Judge Orr RV Park and Storage, PPR-18-040

Please accept the following revised comments from El Paso County Public Health (EPCPH) regarding the project referenced above:

- LEGEND:**
- POSSIBLE OMTS LOCATION
 - POSSIBLE ALTERNATE OMTS LOCATIONS
 - * WATER WELLS MUST BE A MINIMUM OF 100 FT FROM OMTS ABSORPTION FIELDS

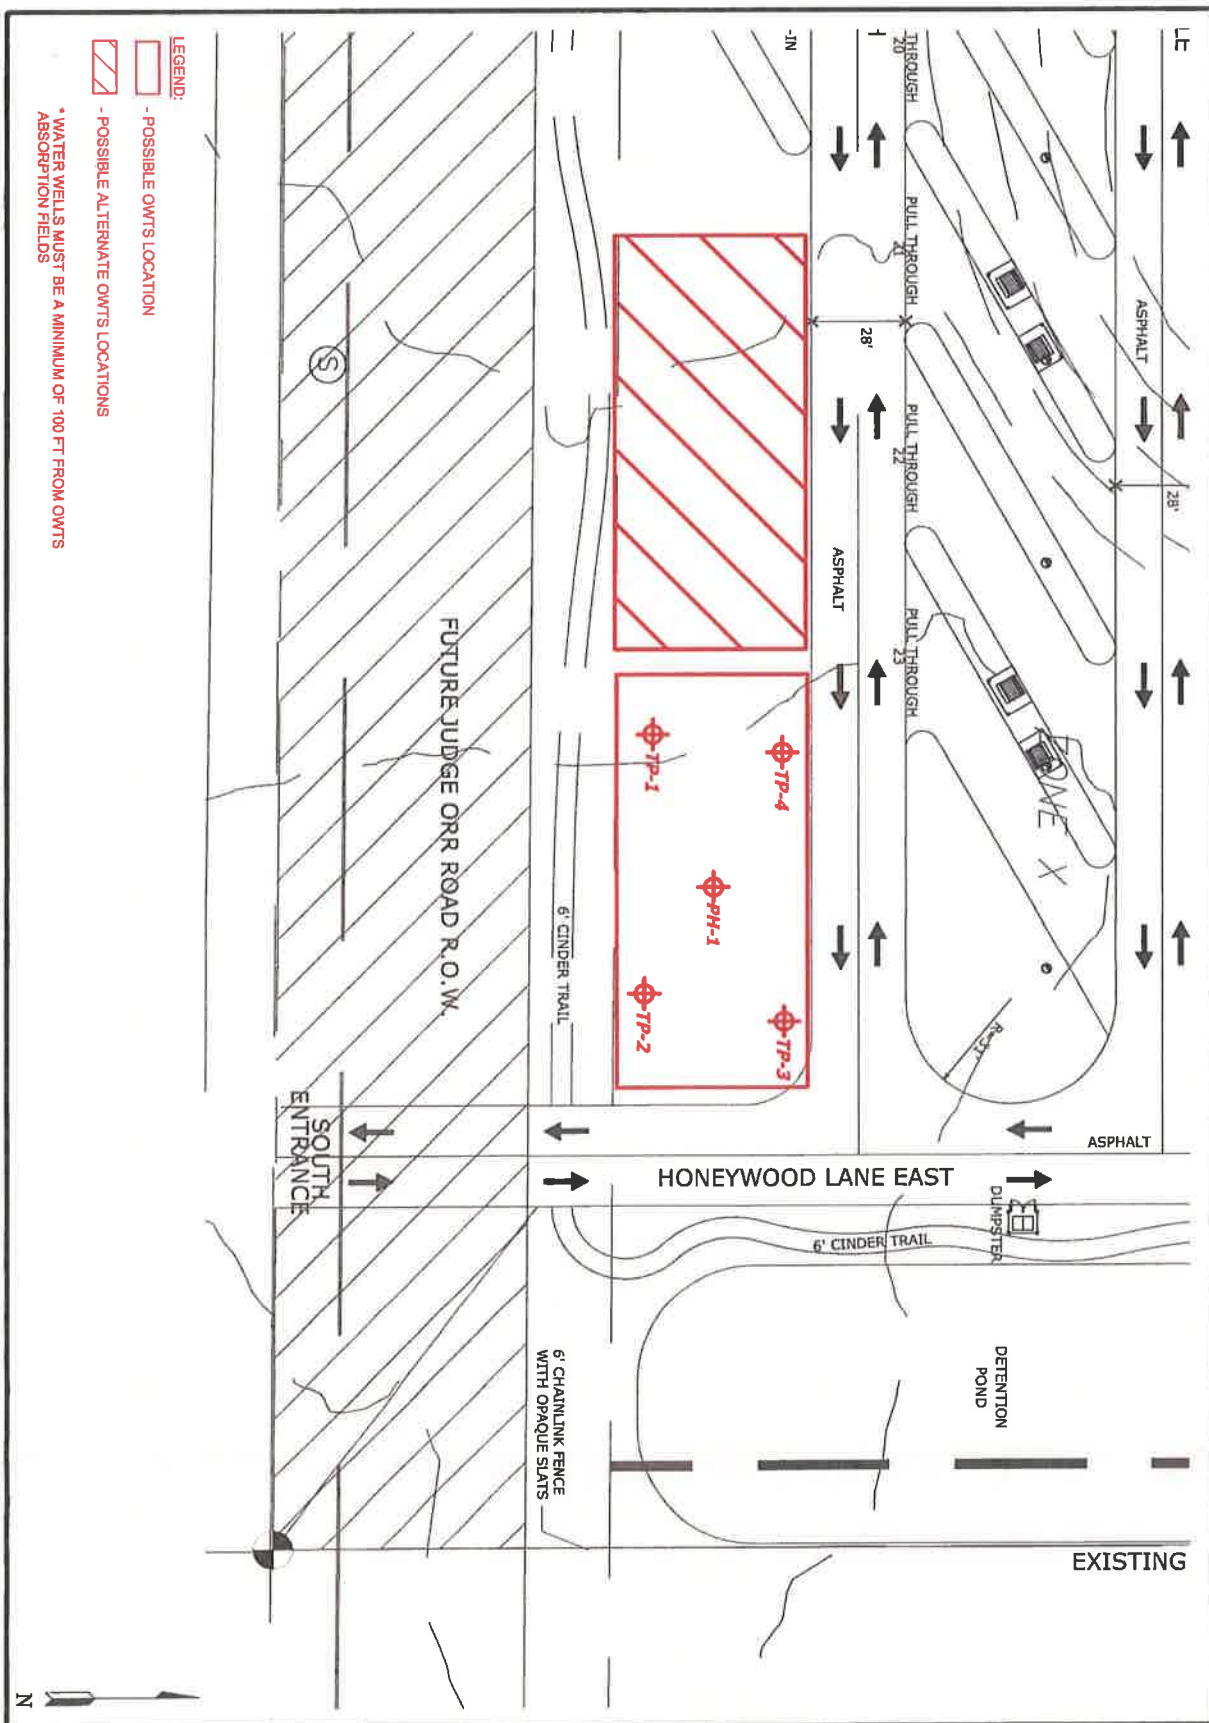
- The Zones of Influence as outlined in CDPHE Water Quality Policy #6 for the soil treatment areas and the existing and proposed well must be mapped and included as a part of the permit application.

- The OWTS soil treatment area (STA) secondary sites and the associated Zones of Influence must also be included with the permit application.
 - The OWTS Regulations in effect at the time of the permit application will be used by El Paso County Public Health for reviewing the application.
